From: Nina Sidhu <Nina.Sidhu@arun.gov.uk>
Sent: 23 September 2020 17:40
To: Amy Myer <Amy.Myer@arun.gov.uk>
Cc: Planning.Responses <Planning.Responses@arun.gov.uk>
Subject: LU/216/20/PL 2 Wick Parade Wick Street Littlehampton BN17 7JQ

Comments from Environmental Health

PROPOSED FLOOR PLAN

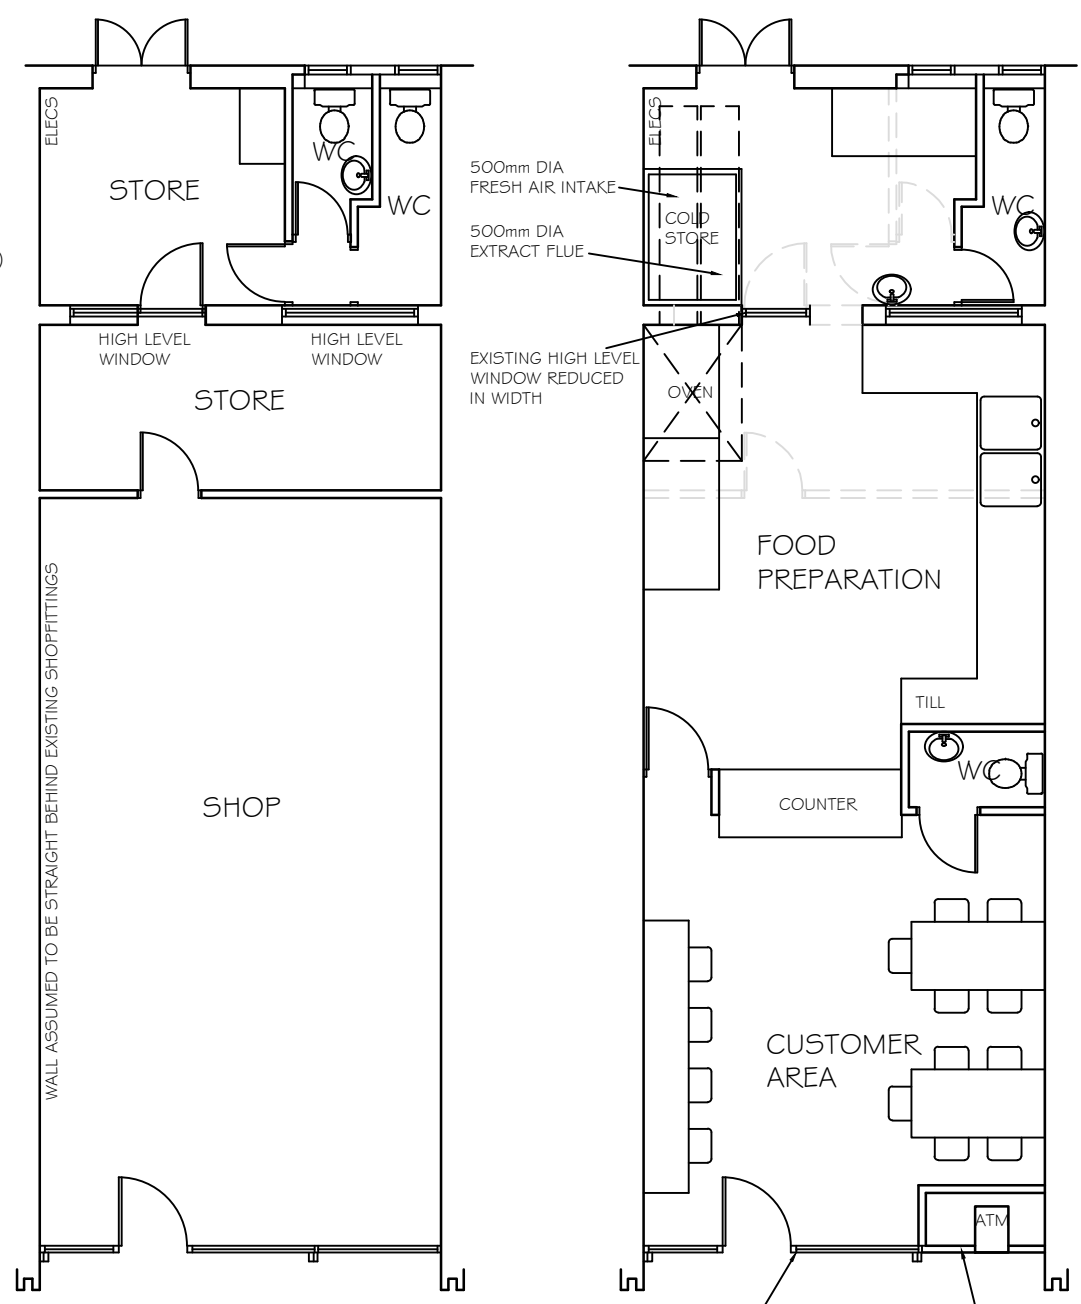
The layout plan shows a toilet opening onto the kitchen/food handling area without an intervening lobby, which does not comply with food hygiene requirements.
